From: Contact Centre (CRM) <contact@ribblevalley.gov.uk>
Sent: 29 May 2024 20:51
To: Planning
Subject: Planning Application Comments - 3/2024/0238 FS-Case-618541271

Planning Application Reference No.: 3/2024/0238

Address of Development: 6 Loach Field Close, Hurst Green. BB79ZF

Comments: 6 Loach Field Close. Proposed two-storey extension to side of double garage, to consist of single garage at ground floor with rooms above and extension of driveway.

EXISTING ELEVATIONS

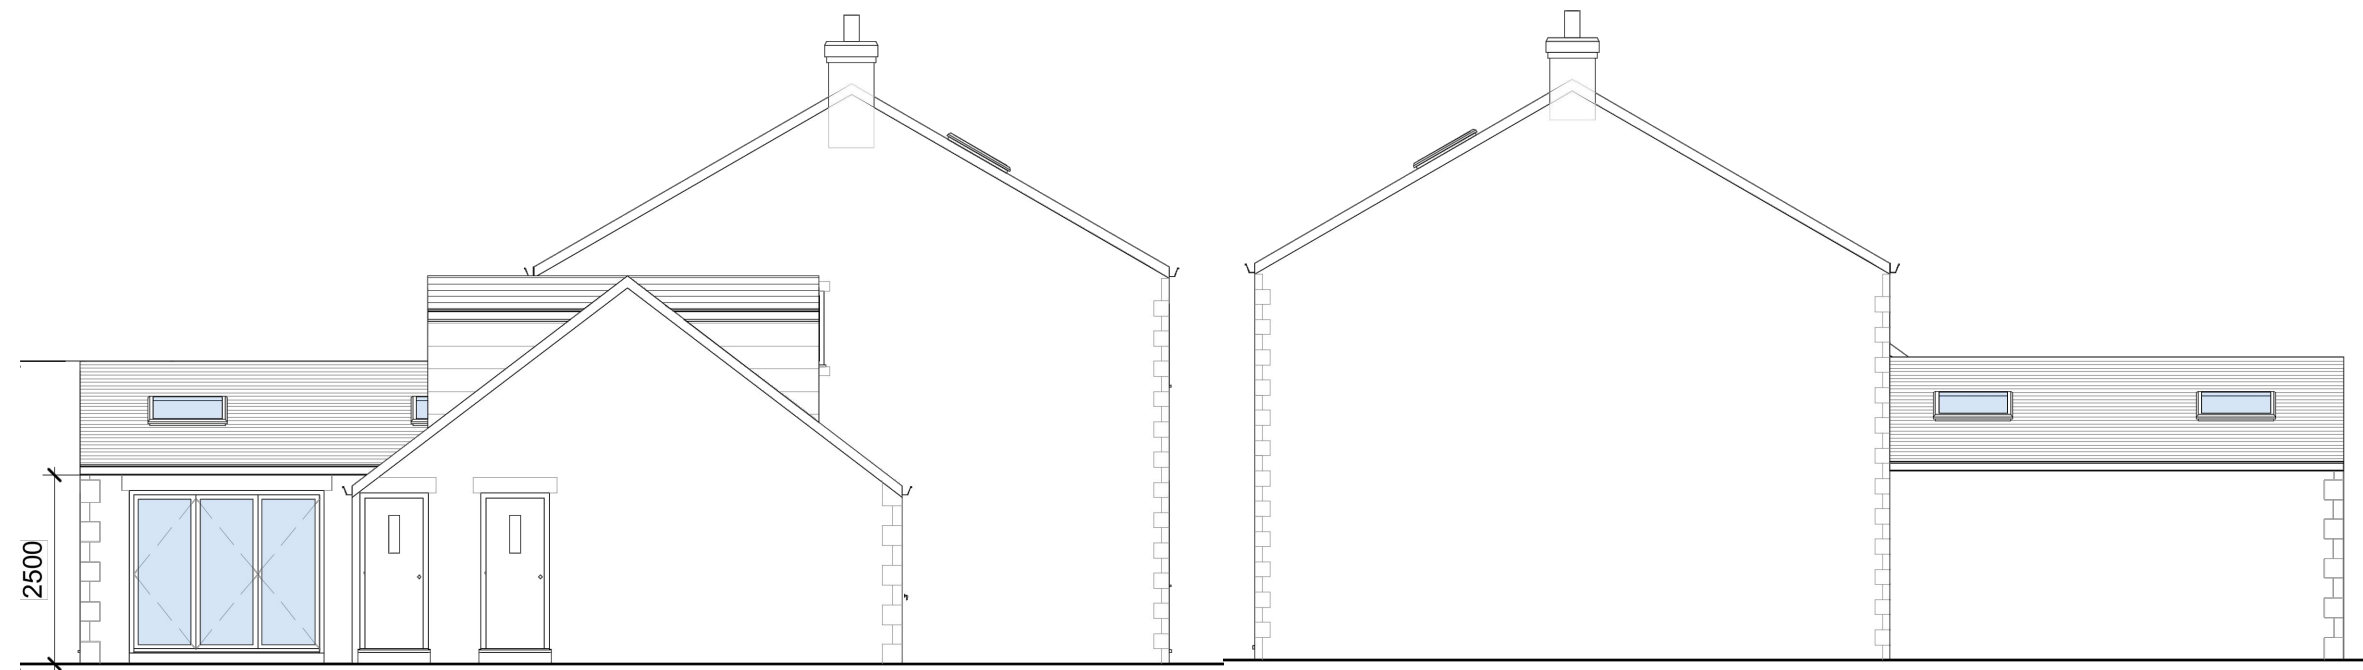
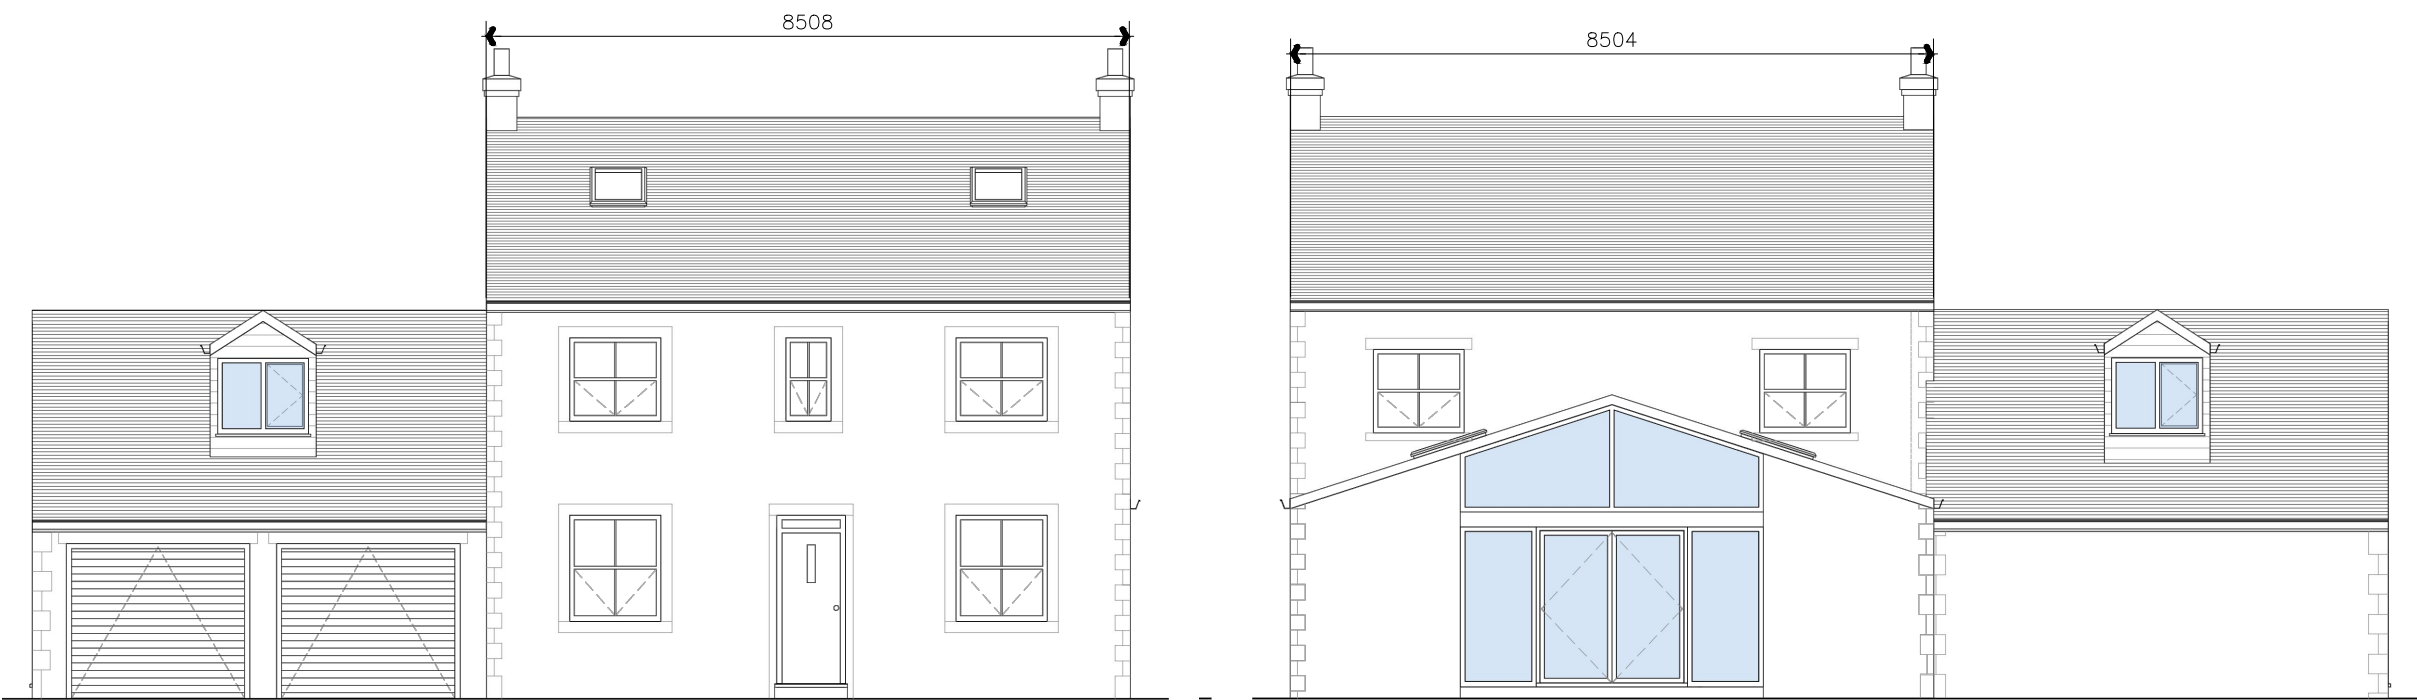
- a) Layout and Density: Recent planning applications and subsequent developments at the property have already increased the footprint of the property from its original planning state. The addition of another building to the side of the property will further increase this at an estimate to nearly 50% additional living space capacity. Also increasing to double of the original floorplate layout of the property.

- b) Design and Appearance: Developments have previously been made at the rear of the property. The development at the side is not in keeping with the current garage dimensions nor in keeping with the character of which the housing development was originally laid out.
